**Consultation Response from KC,
Lead Local Flood Authority**

2025/92674 Land North of, Denby Lane, Grange Moor, Huddersfield, WF4 4BH

Discharge of details reserved by conditions 3 (finished floor levels), 4 (garage details) 7 (remediation strategy), 10 (CEMP), 11 (CEMP: Biodiversity), 12 (drainage), 13 (storm events), 14 (temporary surface water drainage), 15 (surface water attenuation), 16 (road condition survey), 17 (carbon emissions), 19 (materials), 24 (estate street phasing), 26 (waste plan), 29 (cycle parking), 31 (bin storage), 32 (electric car charging point), 33 (boundary treatments) and 34 (crime protection measures) of previous permission 2024/92444 for erection of 21 dwellings and associated works with means of access from Denby Lane

Discharge of Drainage Conditions

TITLE
S104 DRAINAGE LAYOUT

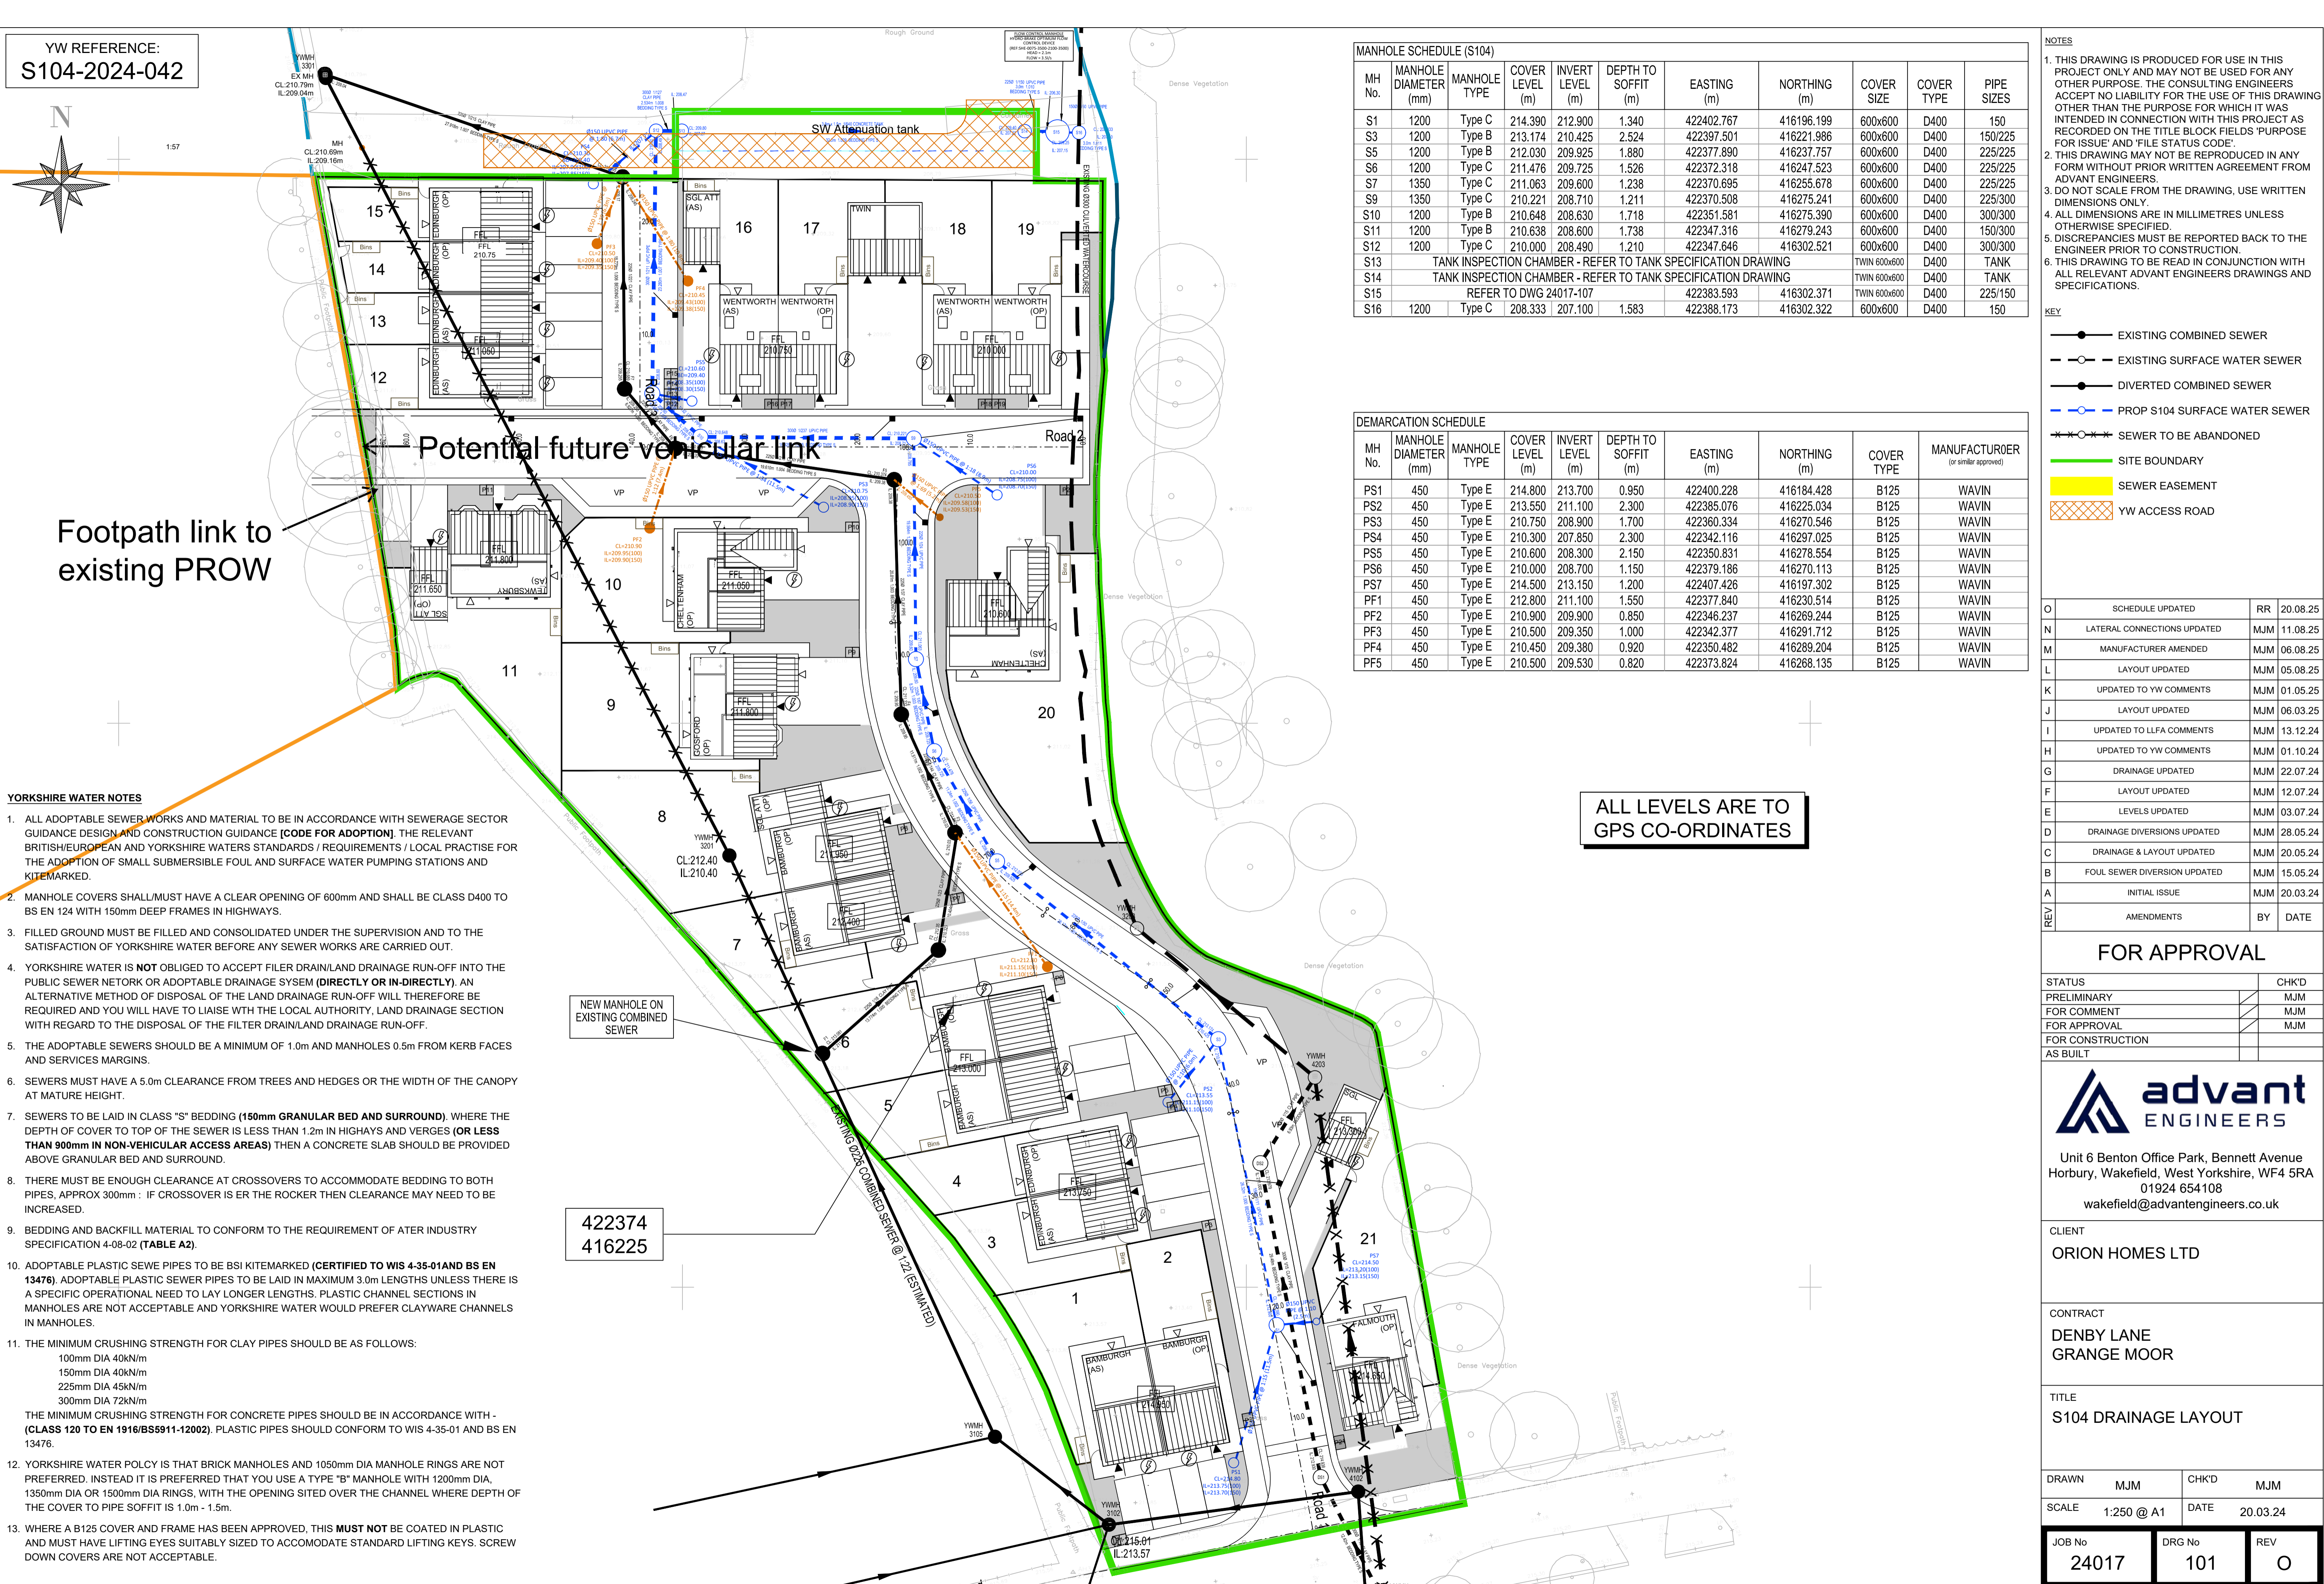
The LLFA confirms that the permanent drainage shown on the Drainage Layout and the associated hydraulic calculations are accepted, therefore Condition 12 can be discharged.

FLOOD EXCEEDANCE DRAWING

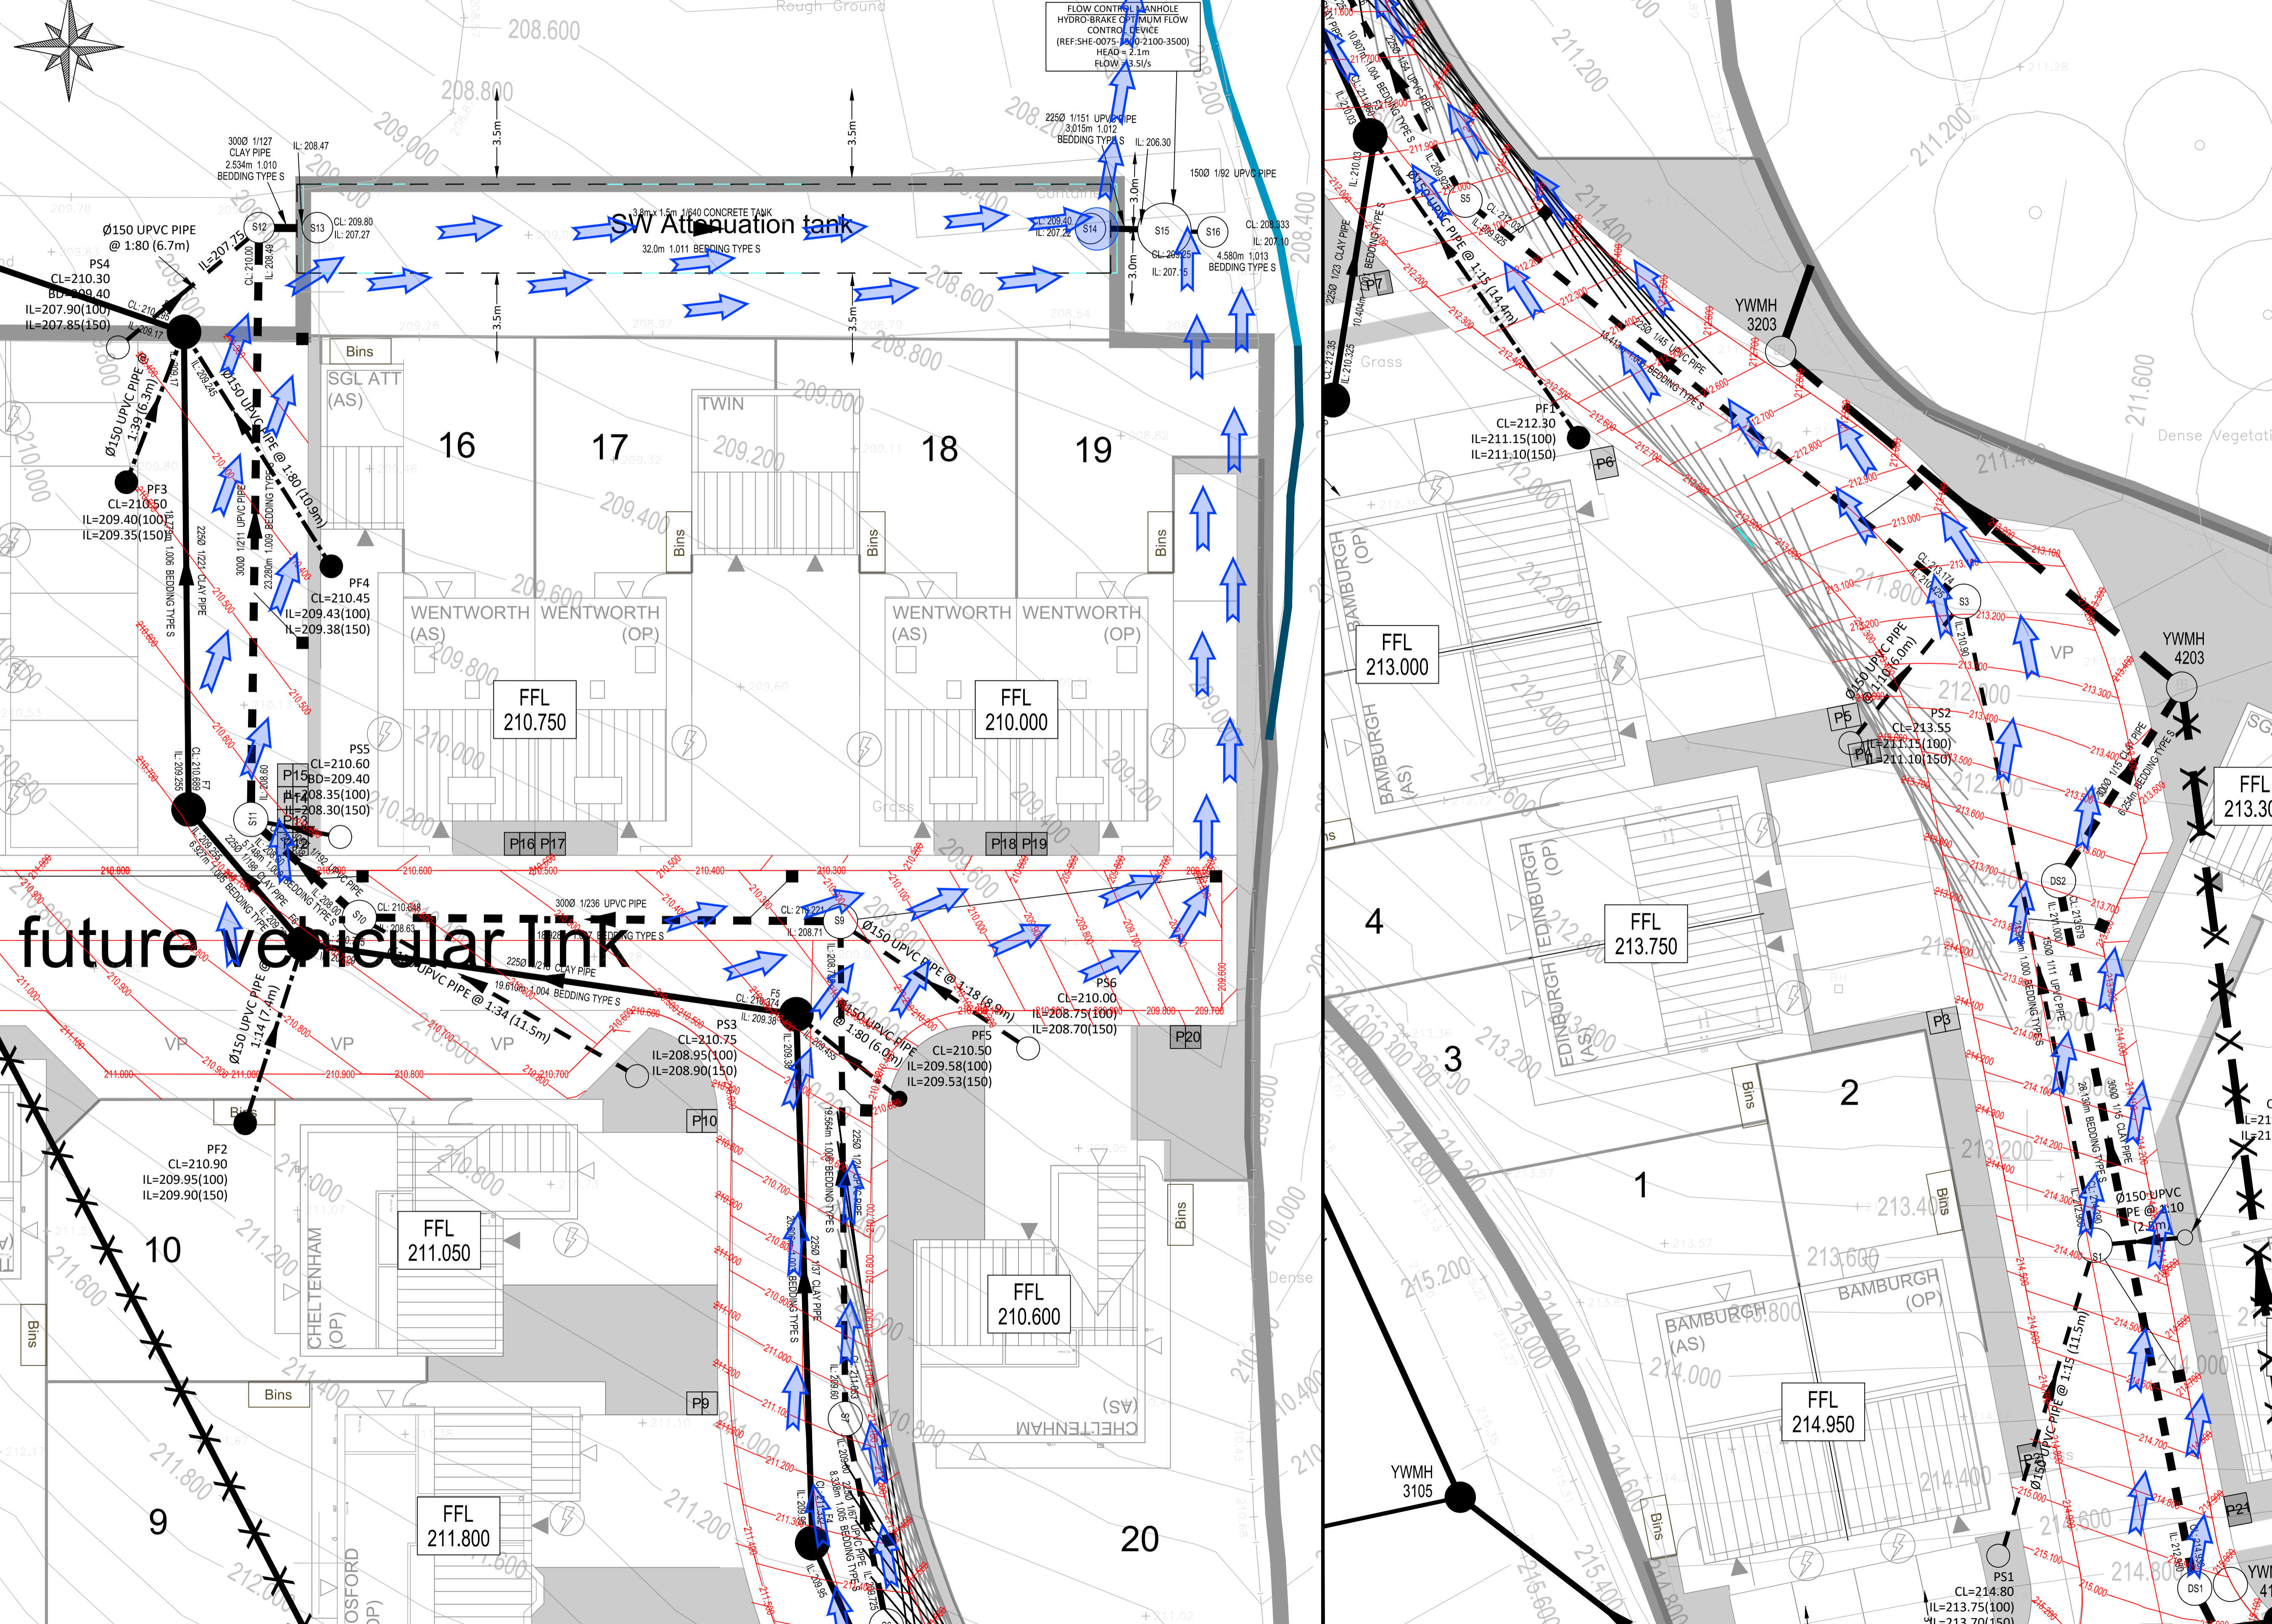
The LLFA confirms that the flood routing shown on the Flood Exceedance Layout Plan are accepted, therefore Condition 13 can be discharged.
